From: planning.scanning@york.gov.uk
Subject: FW: 23/02138/FUL 75 Gillygate

From: MacRae, Claire <Claire.MacRae@york.gov.uk>
Sent: Tuesday, November 28, 2023 1:50 PM
To: Ramadhin, Natalie <Natalie.Ramadhin@york.gov.uk>
Subject: 23/02138/FUL 75 Gillygate

drawing:
 PROPOSED PLANS AND ELEVATIONS

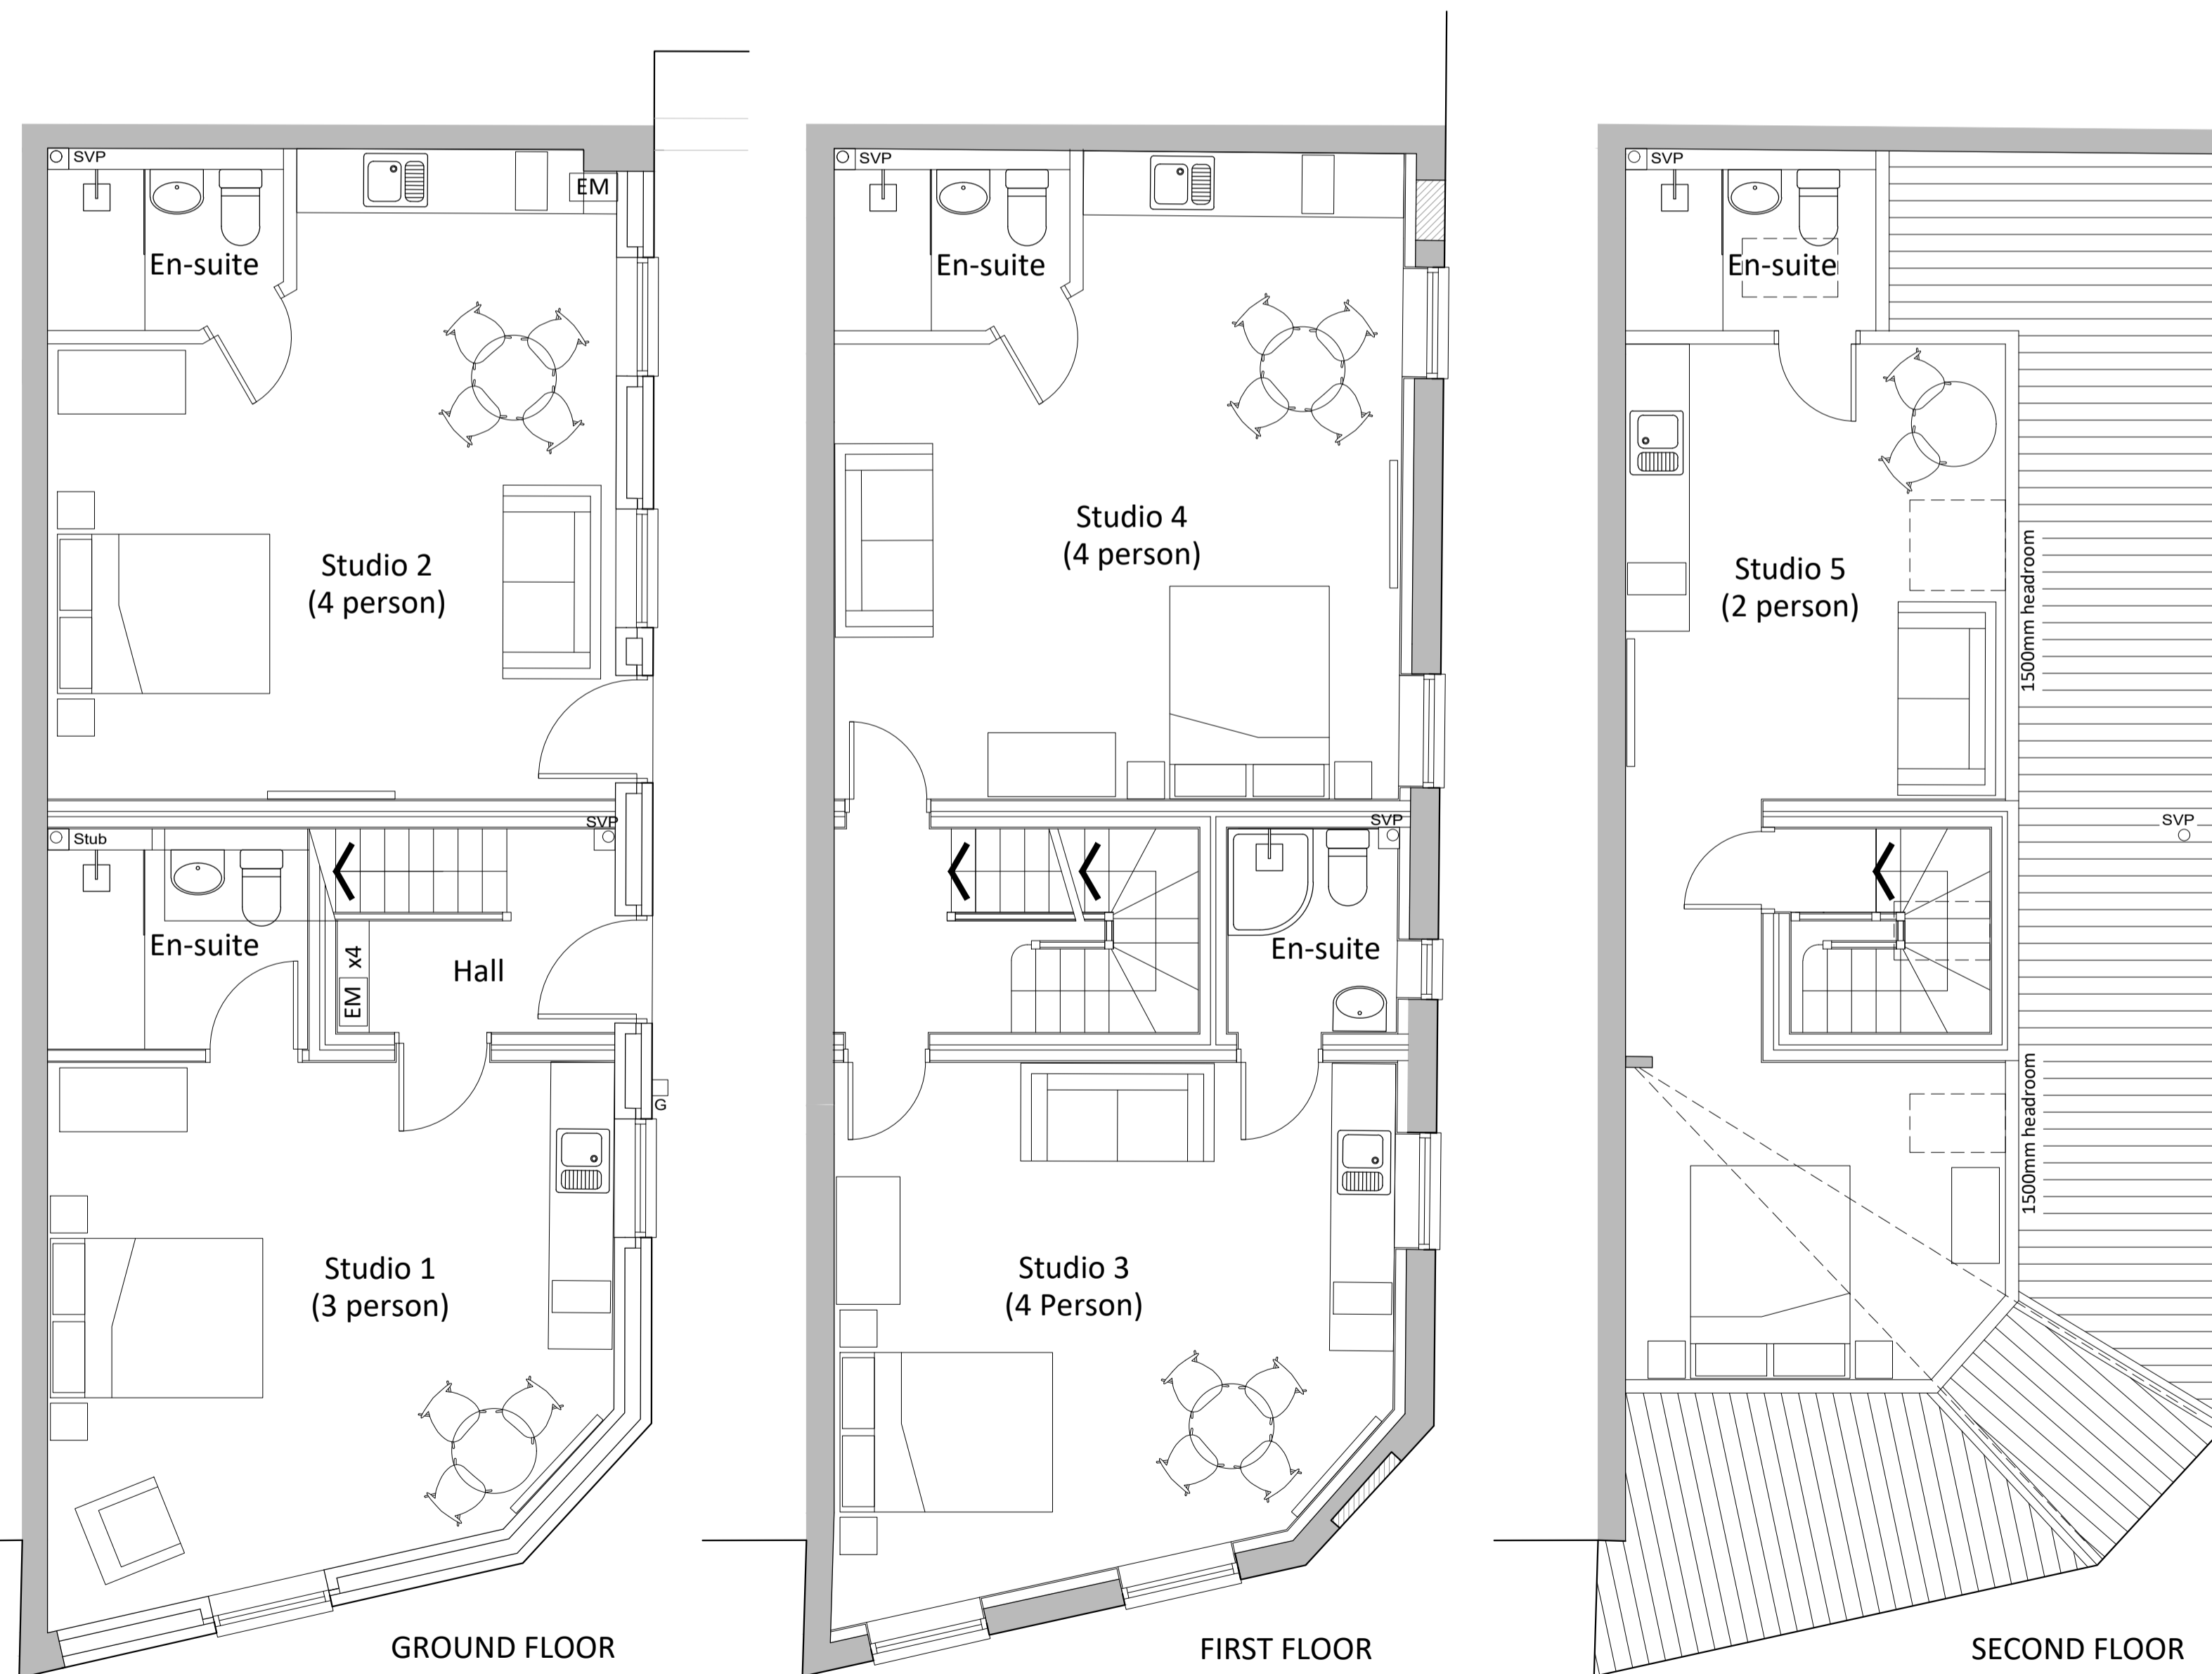
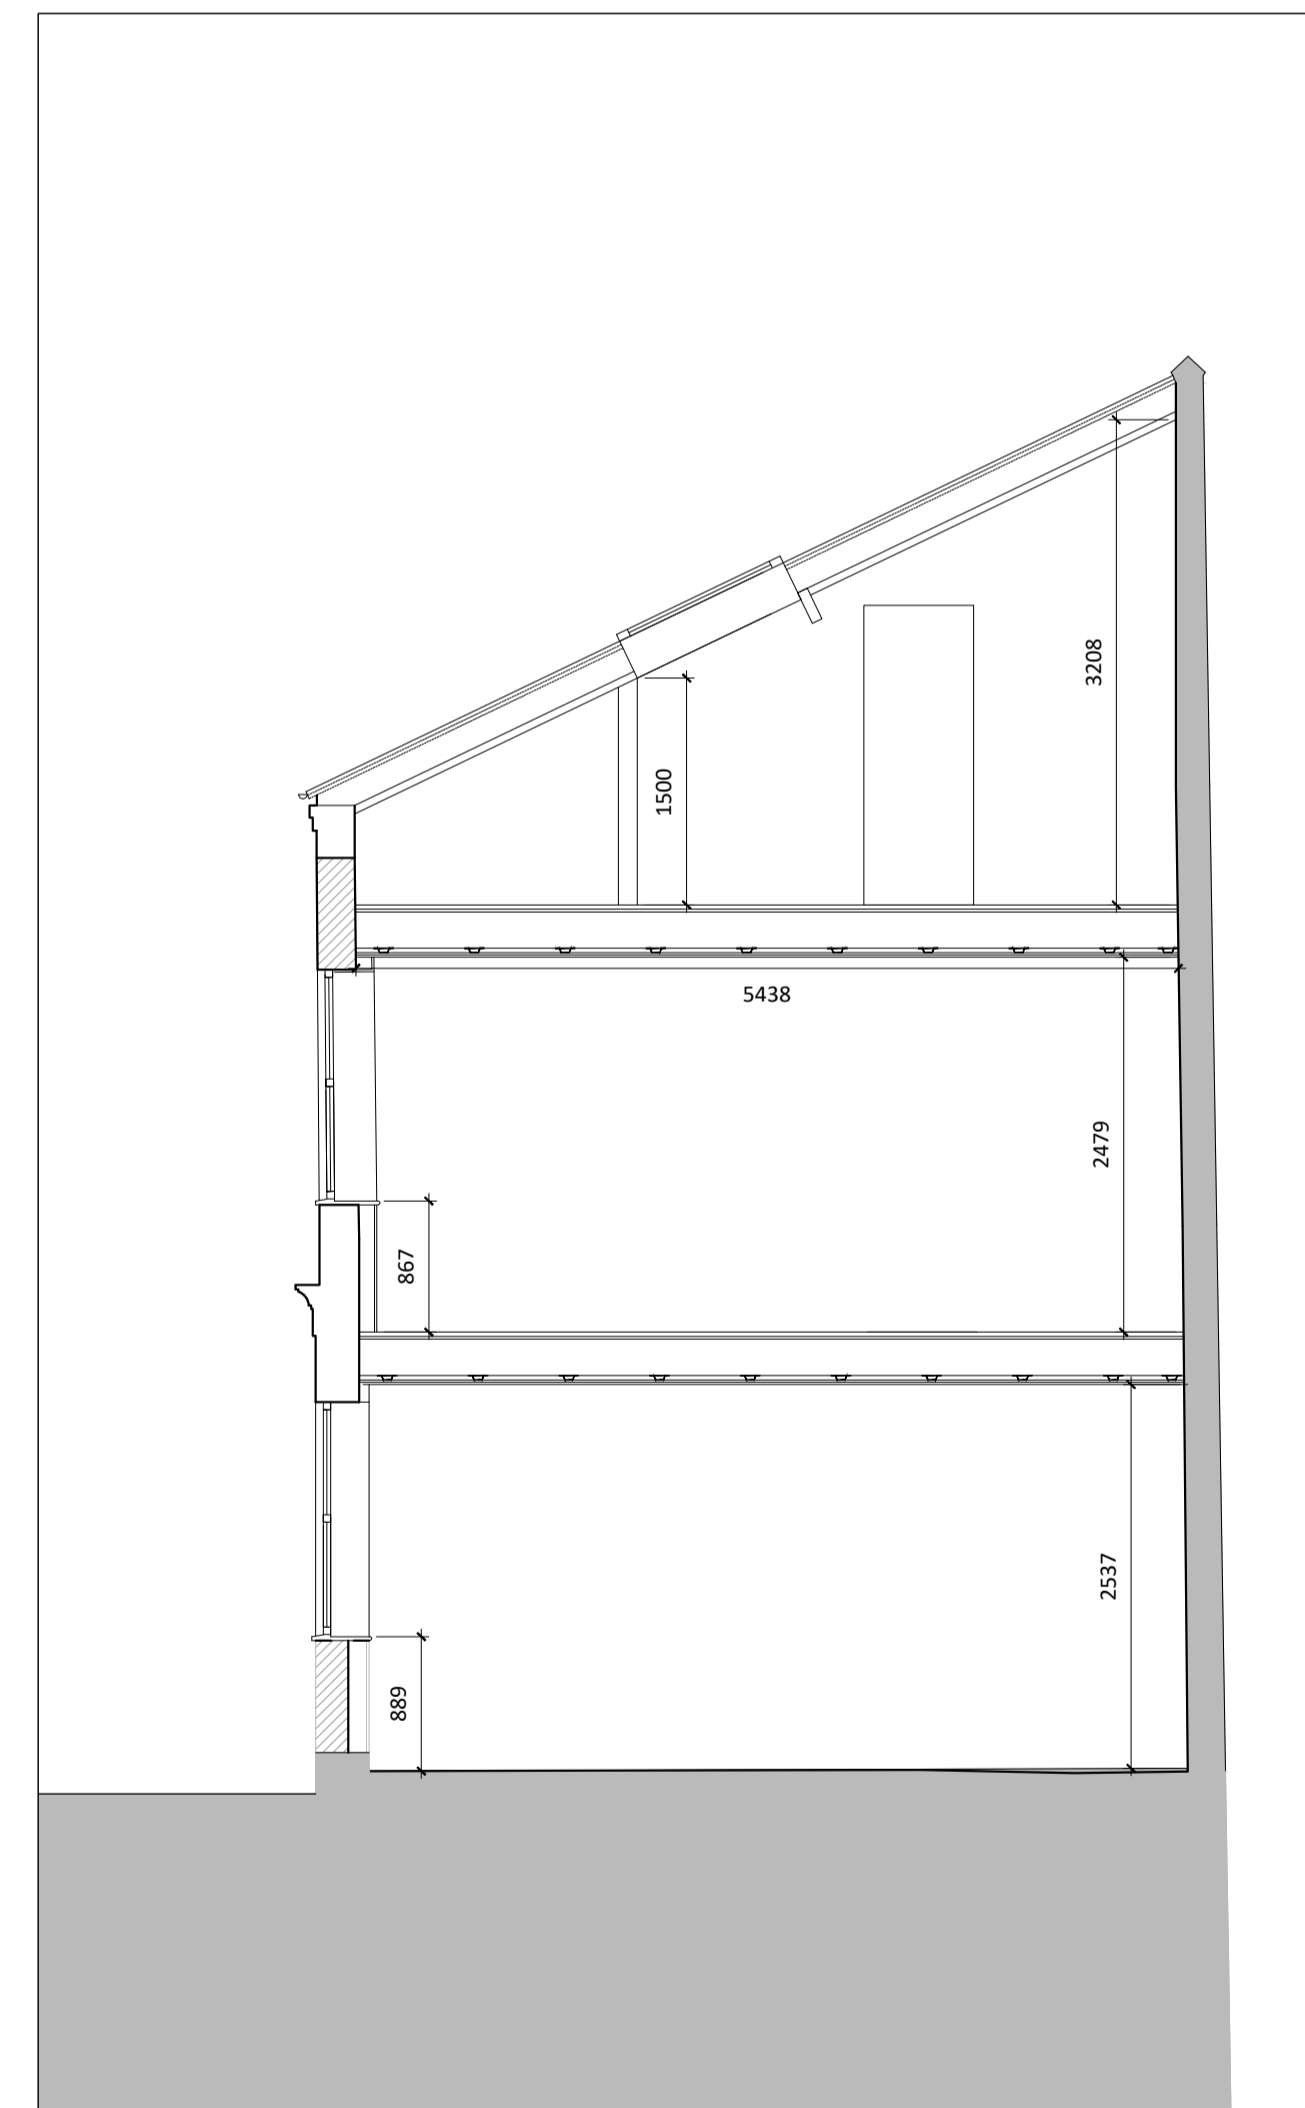
Thanks for the consultation. The application doesn't appear to involve extensive ground disturbing work. However, presumably there will be the need for new drainage for residential use. The proposed drawings indicate that there will be several drains linking to a manhole outside of the building. It isn't clear whether the manhole already exists.

Drainage works for this scheme will need to be monitored by archaeological watching brief as a precaution given the sensitivity of this area. There is the possibility of disturbing human remains here relating to St. Giles church which no. 75 is located upon. Given the small scale nature of the works I have removed the need for a WSI although the archaeologist will need to speak to me before starting on site.

A programme of post-determination archaeological mitigation, specifically an archaeological watching brief is required on this site.

A) No ground disturbing work shall take place until an archaeological contractor has been appointed by the applicant and approved by the local planning authority. The site investigation, post-investigation assessment and provision for analysis, publication and dissemination of results and archive deposition shall be secured in accordance with standards set by the Chartered Institute for Archaeologists and LPA.

B) A copy of a report shall be deposited with City of York Historic Environment Record to allow public dissemination of results 3 months of completion of fieldwork or such other period as may be agreed in writing with the Local Planning Authority.
